Subject: RE: Please find attached amendment on planning application Ref: BR/63/19/PL

Engineers Further Comments Regarding Surface Water Drainage

APPLICATION NO: BR/63/19/PL

Site Address: 15-17 Kew Gardens Bognor Regis PO21 5RD

Project:-			
Proposed Residential Development 15-17 Kew Gardens Bognor Regis West Sussex			
Title:-			
Proposed Site Plan			
Client:-			
Farnden Developments Ltd			
Scale:-			
1:100 (@A1)			
Drawn By:-		Checked By:-	
PJD			
Date:-		Date:-	
14/02/19			
Job.No:-		Drg.No:-	
180037		03

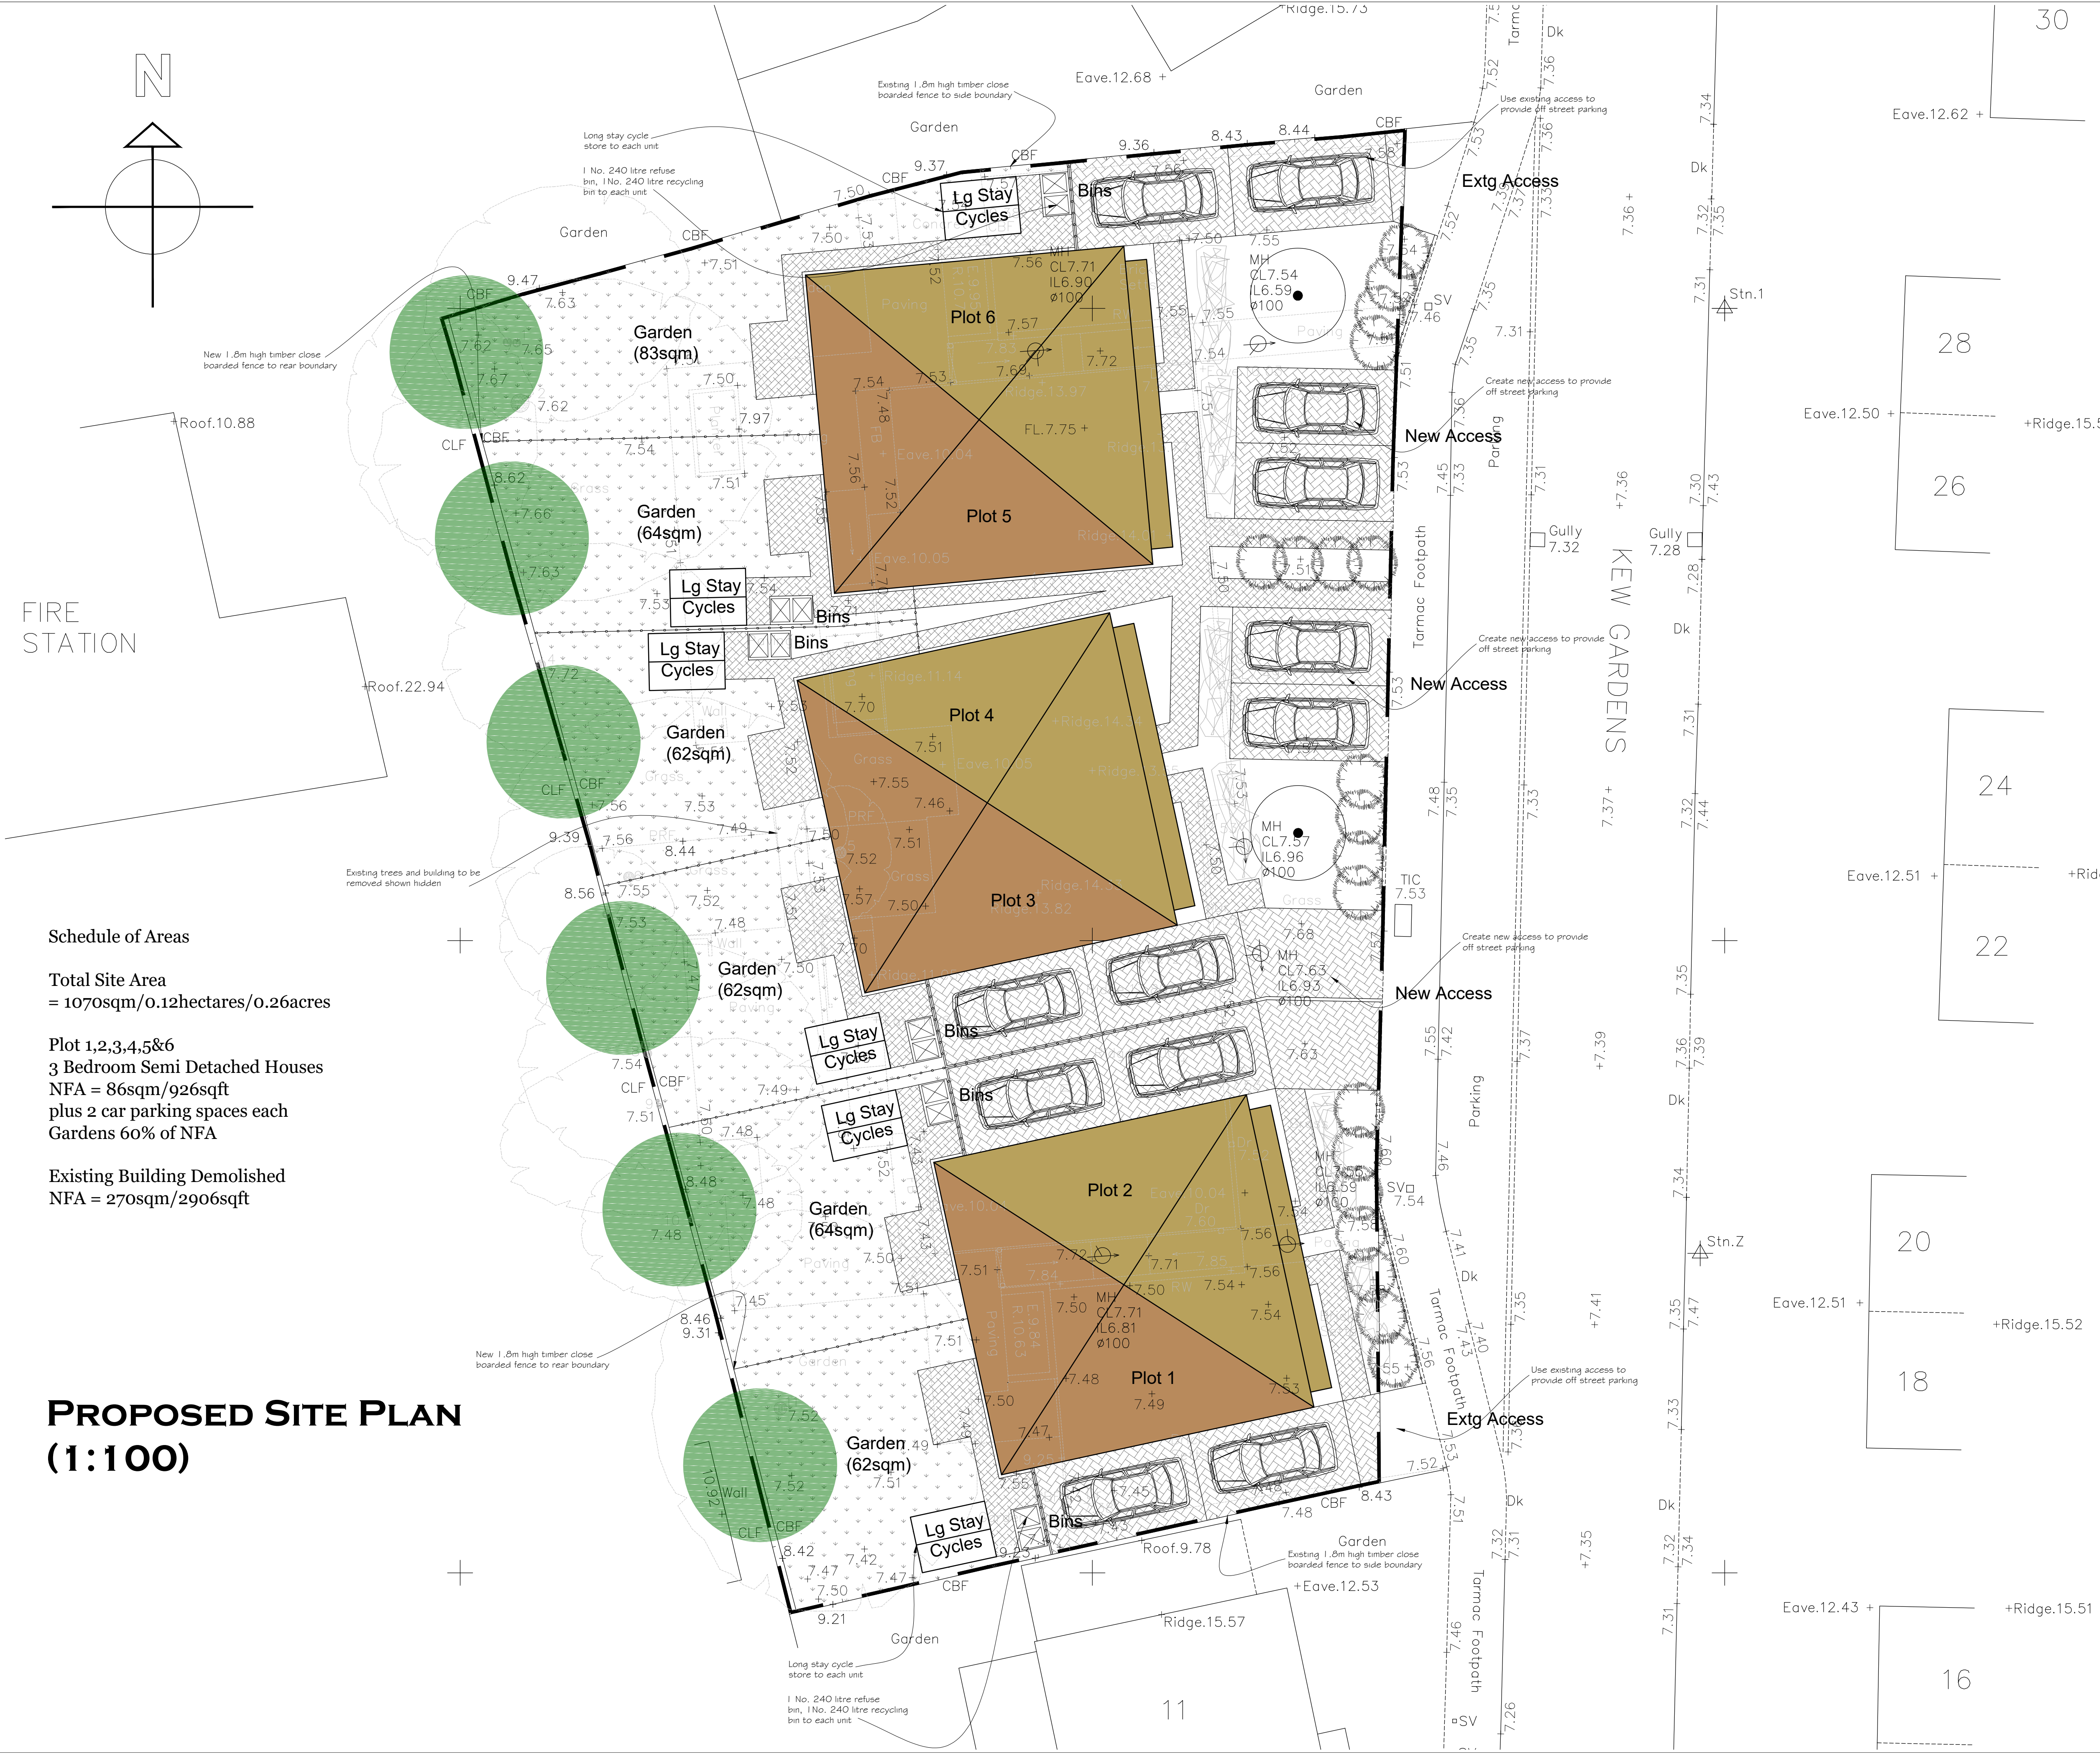
The revised site plan shows greater space is now available for surface water drainage. There is still very limited space available to the rear of plots 1, 2 and 6. Surface water drainage for each plot should be provided within that plots curtilage.
